Walden Preserve 2 Filing No. 4A
Traffic Technical Memorandum
(LSC #184810)
September 7, 2018

Summary of Comments on LSC Responses to County Comments (10-19-18) WORKING FILE.pdf

Figure 7
Directional Distribution of Site-Generated Traffic
 Walden Preserve 2 (LSC #144380)

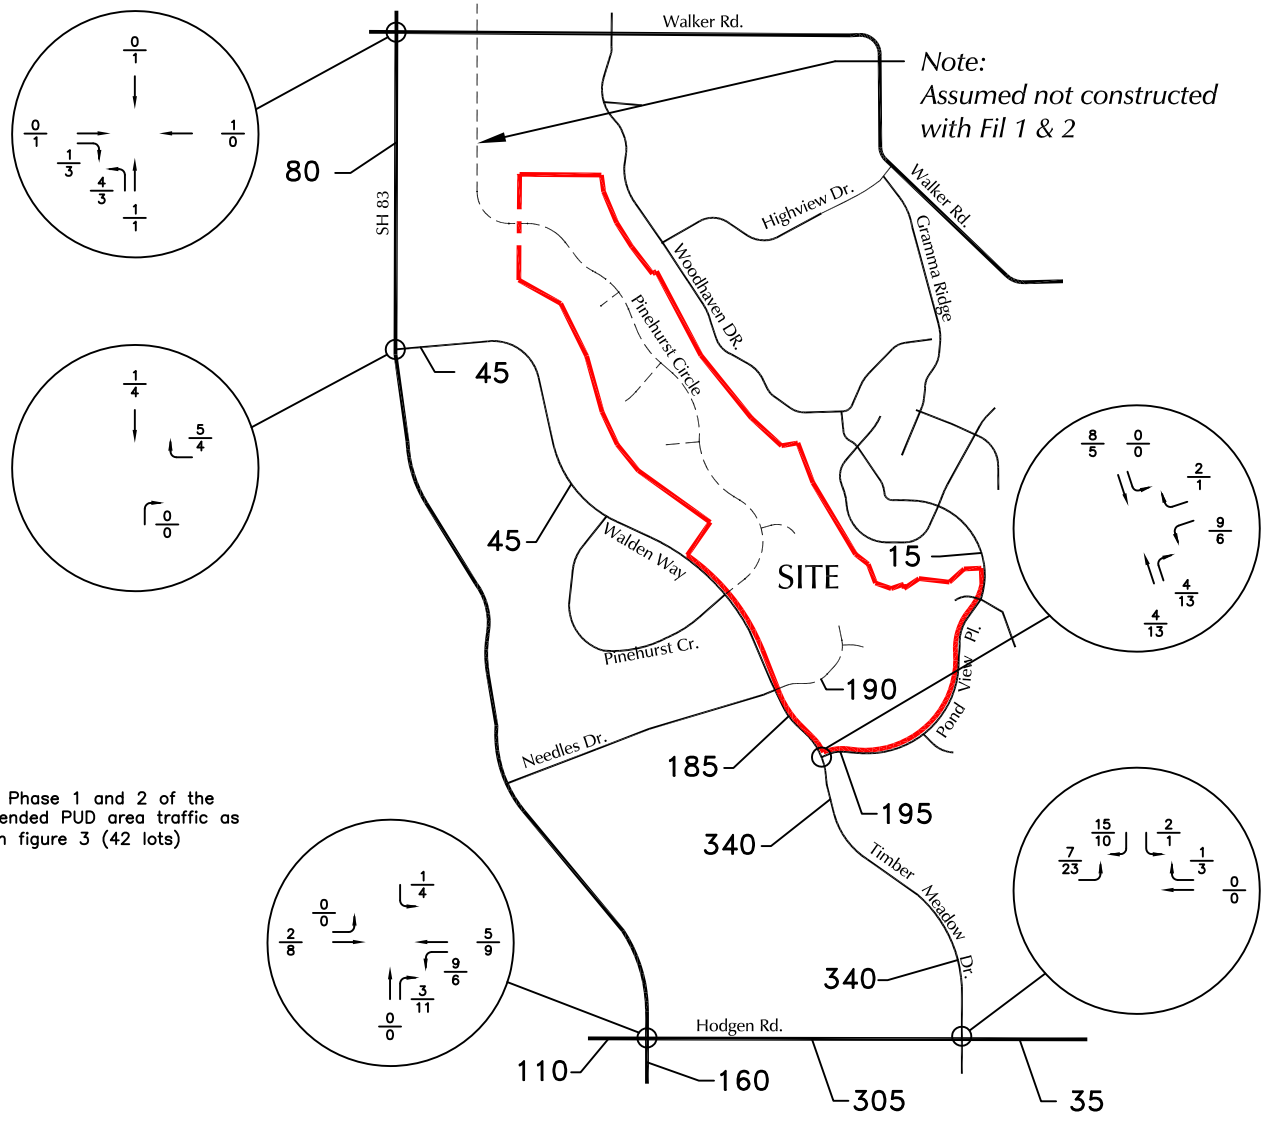
Provide an explanation in the Trip Distribution Narrative why the distribution assumes a approximately half of the trips going out from Walker Road would go back in through Hodgen in the short-term but not on the long-term.

Identify the % Distribution going to Timber Meadow Dr.

Revise the legend. Staff assumes the denominator is "Long-Term"

This figure has been removed to avoid confusion. Text has been added to clarify that the distribution from the PUD report has been used to distribute the trips in the short term.

This figure has been removed to avoid confusion. Text has been added to clarify that the distribution from the PUD report has been used to distribute the trips in the short term.

This figure has been removed to avoid confusion. Text has been added to clarify that the distribution from the PUD report has been used to distribute the trips in the short term.
